DELEGATED DETAILS DECISION

Report of the Head of Planning, Building Control, Sport & Green Spaces

Address 37 ST JOHN'S ROAD UXBRIDGE

Development: Details pursuant to conditions 3 (Materials), 16 (Landscape Scheme) and 20 (Footpath) of planning permission Ref: 15811/APP/2014/2444 dated 6/02/2014 (4 x 2-storey, 3-bed, semi-detached houses with habitable roofspace and 3 x two storey, 3-bed, detached houses with habitable roofspace with associated parking and amenity space involving demolition of existing B1 office building)

House Type 1 Materials

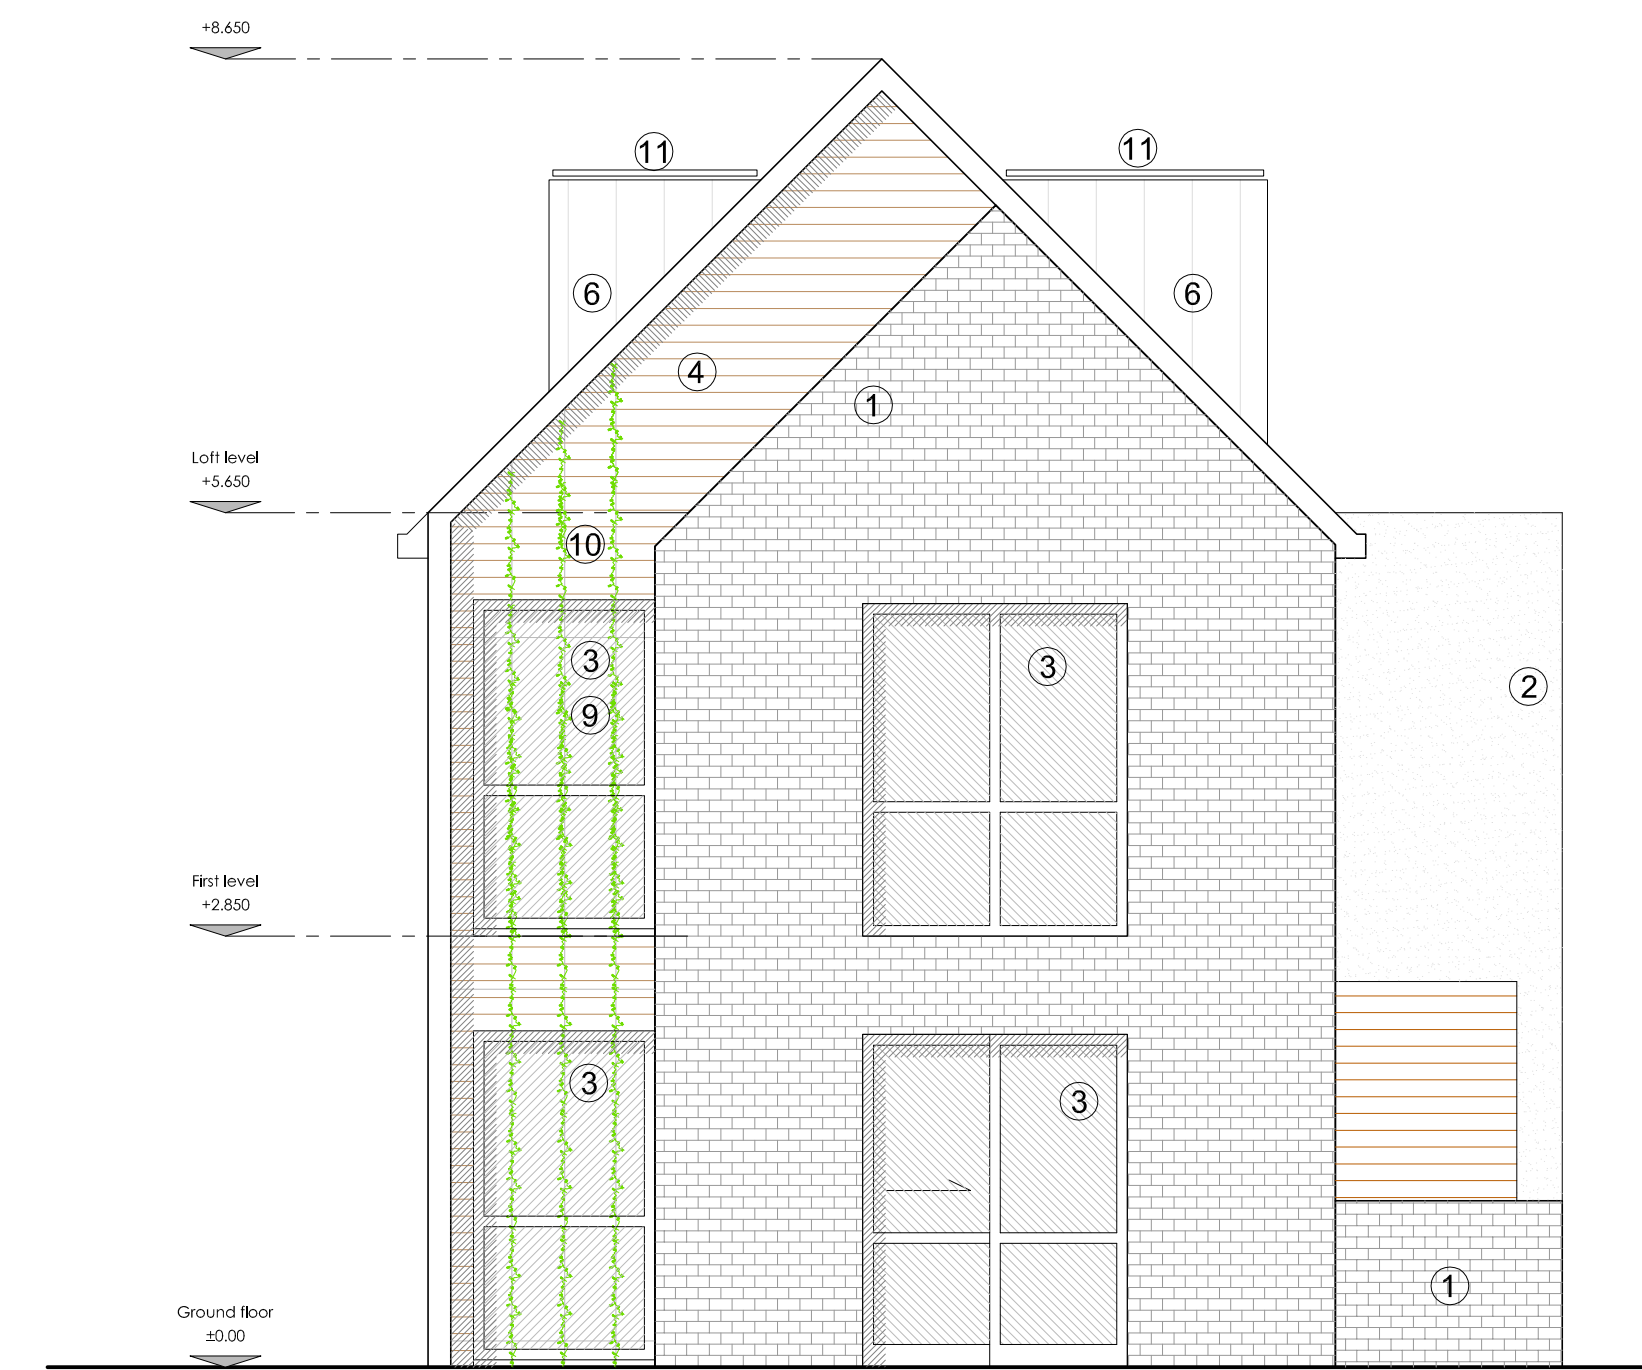
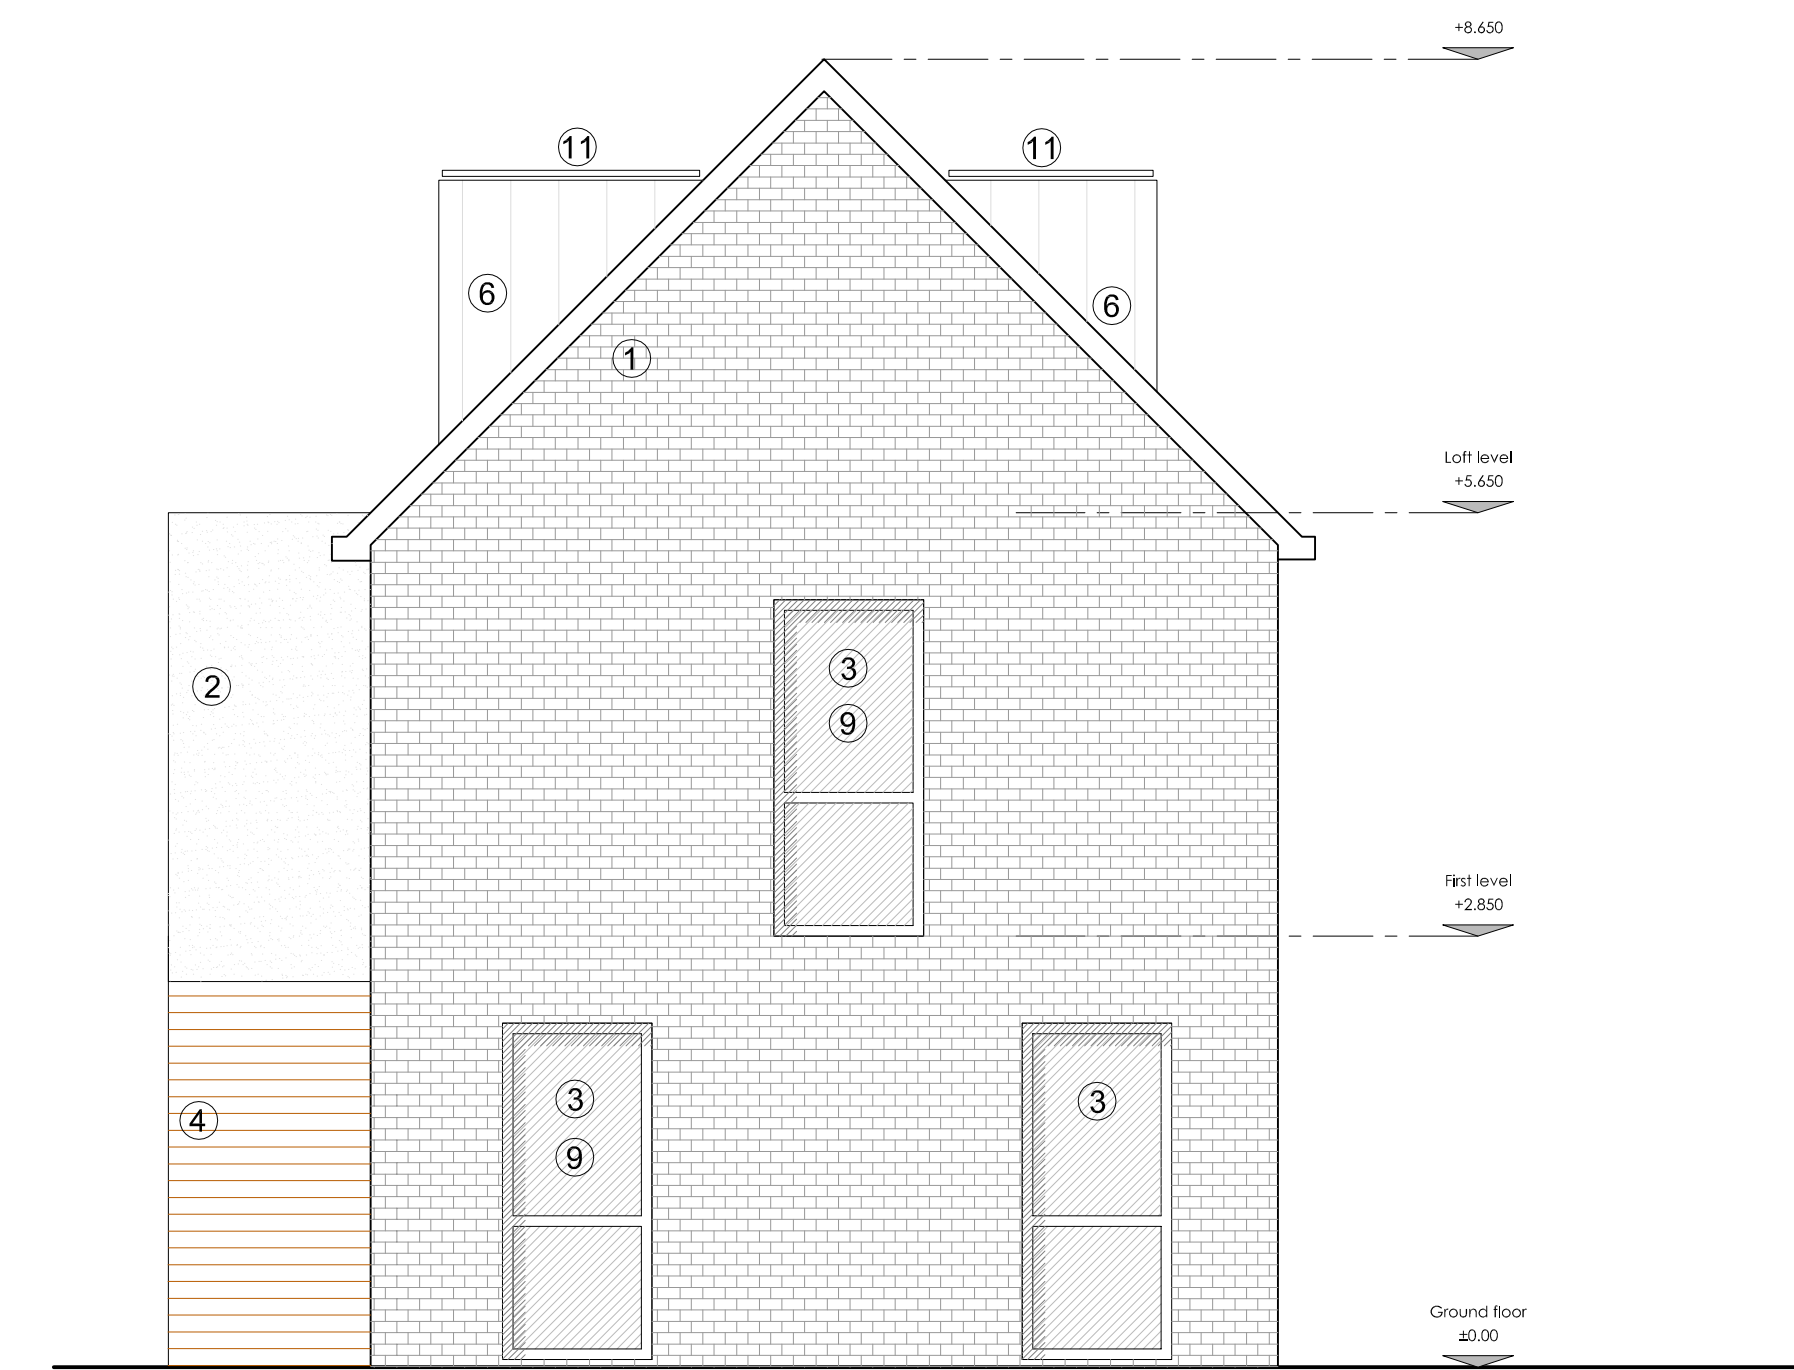
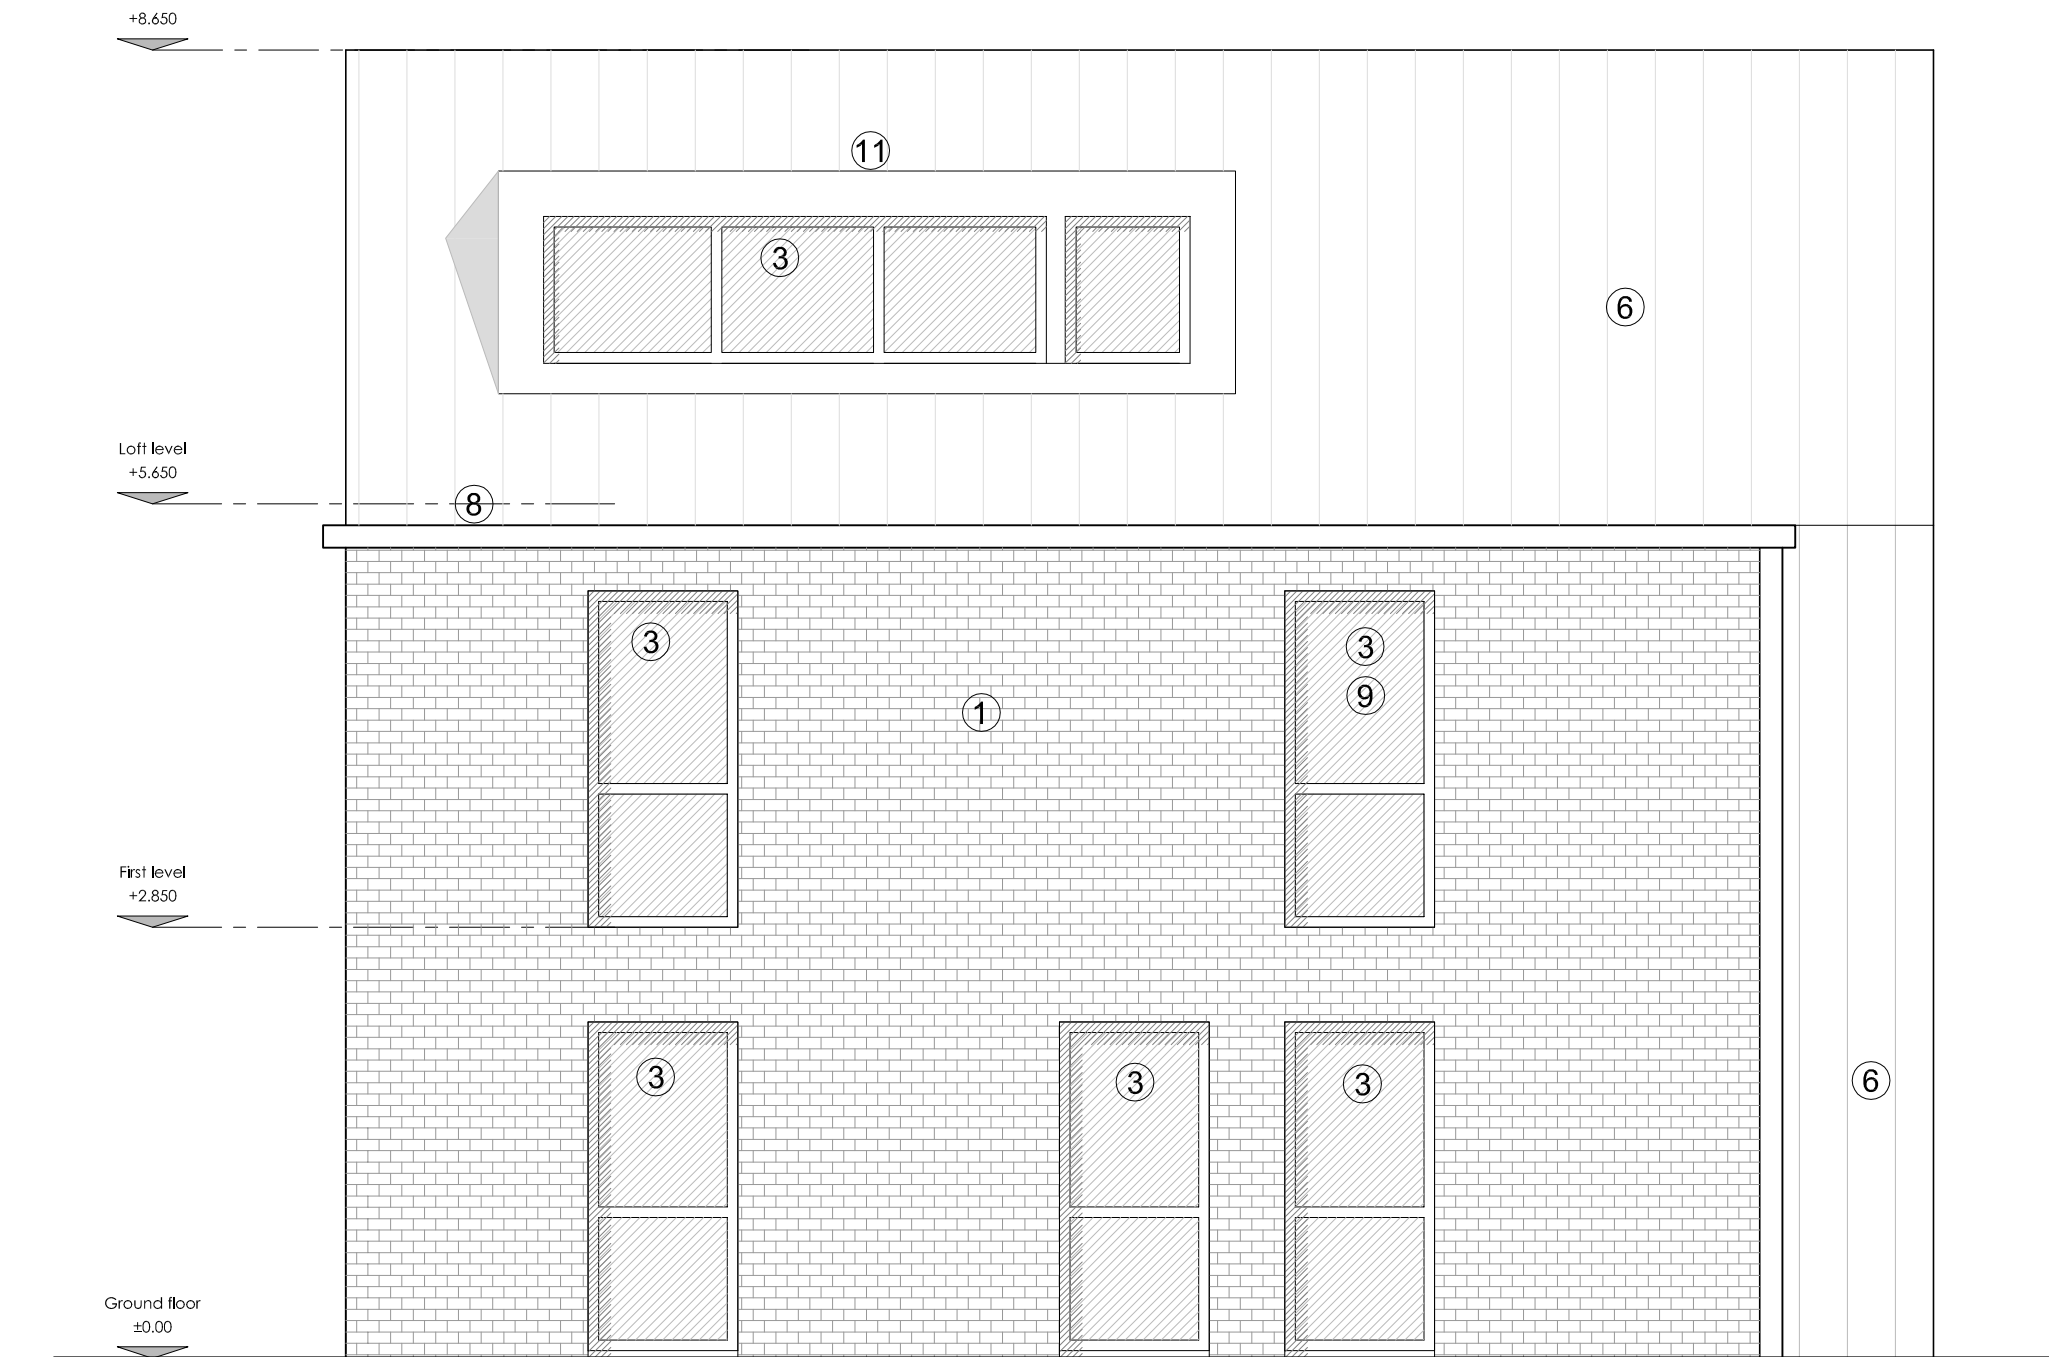
Condition 3 - The plans and photographic samples submitted in relation to the proposed materials to be used at the site are considered to have an acceptable impact to the visual amenity of the surrounding area and therefore meet the requirements of the condition. The materials are listed in plan ref 740-150/A.
